321 Commercial- Marriott Courtyard Hotel Signage and Wayfinding

Summary guidance re permitting process (related to proposals on attached plan and as discussed and revised at site meeting Aug 5, 2014); all subject to the Zoning Administrator's final review and interpretation.

FOUNDRY  
LANE

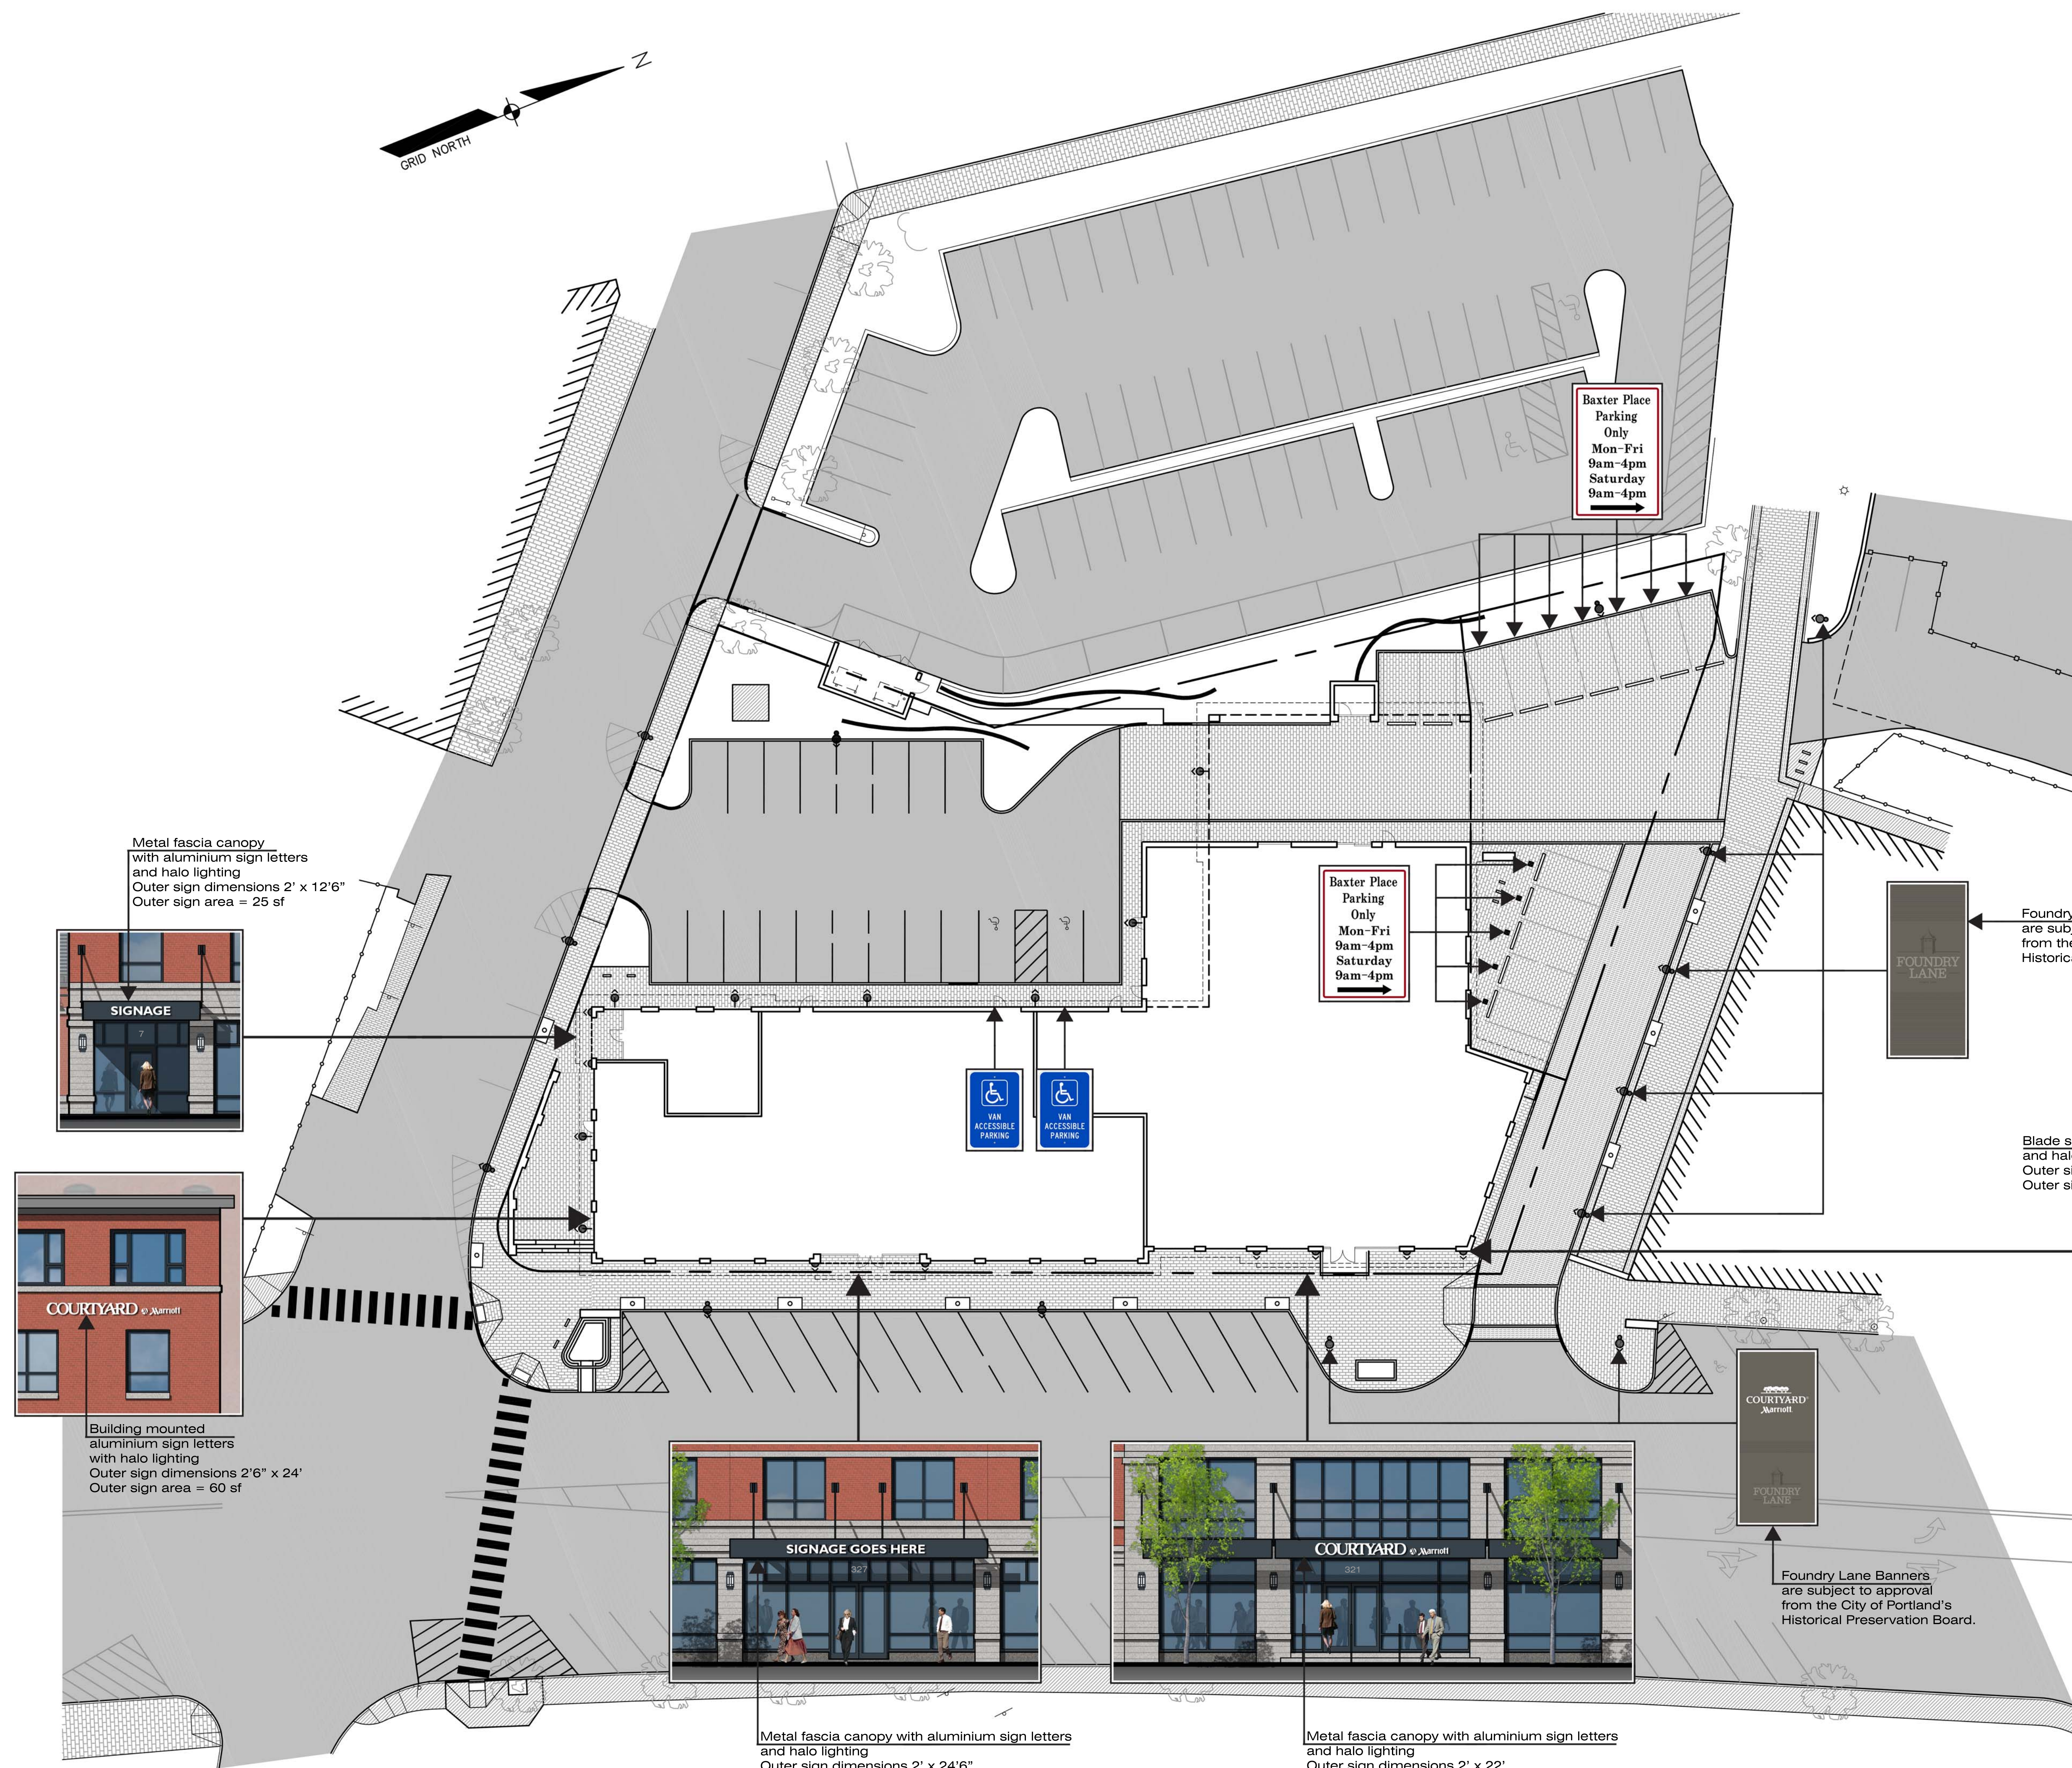
Proposed sign/item	What City interprets this as	Permit required?	Review process	Comments
Large banner mounted on Commercial St. light column (ROW) saying "Foundry Lane"; (same would apply if the one at the York St. end is in ROW)	Directory sign being erected on behalf of the City to identify Foundry Lane.	Probably not; may need license (research needed) [See 14.368 and 14-369.5 Table]		Supported by Tom Errico and Deb Andrews and Jean Fraser at meeting 8.5.14.
Two-three banners on light poles along Foundry Lane (private) that say "Foundry Lane"(mixed in with those below)	Directional sign on private property (no commercial content)	Understand these do not need permits		
Six banners on light poles along Foundry Lane (private), 3 say "Marriott"; 2 say "Baxter Place"; 1 Cannery; and other one has a business name on it...	Banners; are permitted without prior approval if do not exceed the sum of all building and freestanding signs for that use on that lot	Needs permit as may exceed overall sign allowances [See 14-368 (a) 1.]	Sign permit reviewed by Zoning Administrator; likely this will be denied under zoning at least re Marriott as Marriott already have max. allowable signage; can request variance and then it would be reviewed under site plan standards.	OK with Deb Andrews as long as dates are accurate and design is as was shown in plans at meeting. No objections from Tom Errico or Jean Fraser

Metal portable sign located in ROW in bump-out nearest Foundry lane (referring to Valet Parking)	Portable sign in City right of way (A-frame) that is directory in purpose <i>Portable sign defined as : Any sign not permanently attached to the ground or some type of permanent structure, or a sign designed to be transported including, but not limited to, signs designed to be transported by means of wheels; signs converted to or located on A- or T-frames; menu and sandwich board signs; inflatable signs or large-scale tethered balloons;...</i>	Appears to be allowed subject to permit if meets 14-370; also needs license [See 14-368.5 Table, bottom line under B5b, and 14-370]	Sign permit reviewed by Zoning Administrator. License (not sure re this; Legal & Legal would review at some point)	Supported by Tom Errico Deb Andrews would prefer a more attractive sign design
Metal portable sign located in ROW in bum-pout nearest Maple Street (referring to Valet Parking)	(anticipated that this one will be removed)			At meeting it was understood that Tom Errico and Vin Veroneau agreed that this one should not be there as it directs vehicles incorrectly.
